**The Children's Hospital at Westmead - Multi-storey Carpark (SSD-10434896)
Corner of Hawkesbury Road and Hainsworth Street, Westmead
Response to Submissions Report**

ATTACHMENT 1 – KEY ISSUES

SECTION  
4  
Section 4

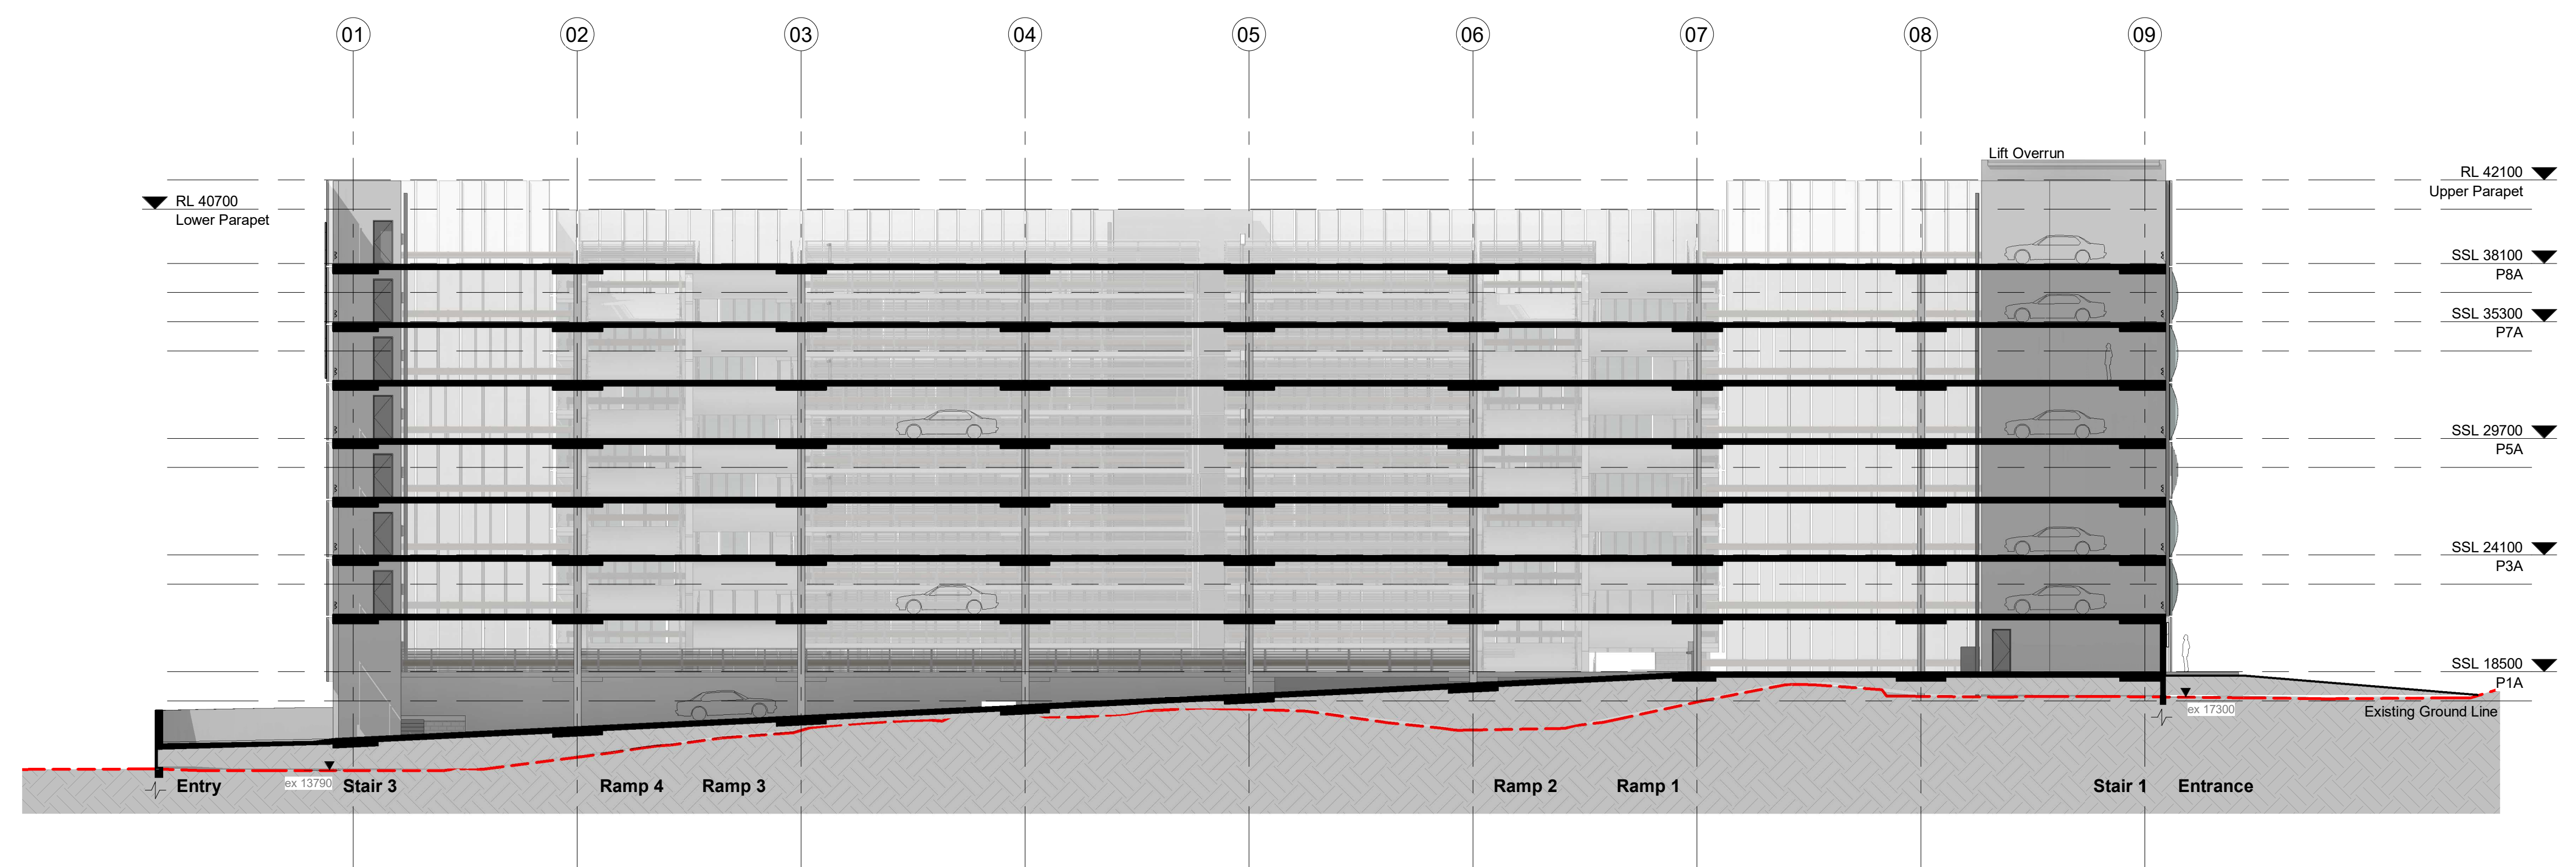
5. Updated architectural / landscape plans are to be submitted providing:
 - a) further detail of the proposed solar panel façade and/or roof canopy design in accordance with the ESD report.
 - b) confirmation of compliance with relevant Australian Standards for off-street parking facilities (parking space dimensions).
 - c) identify the location of motorcycle parking spaces.
 - d) the inclusion of public amenities, preferably in the vicinity of disabled parking spaces.
 - e) the integration of a retail offering adjacent to the kidsway and playground area.
 - f) the detailed design of the new universal access playground, including an investigation into potentially relocating these facilities to the vacant turfed area opposite the Remembrance Garden to enable improved solar access.
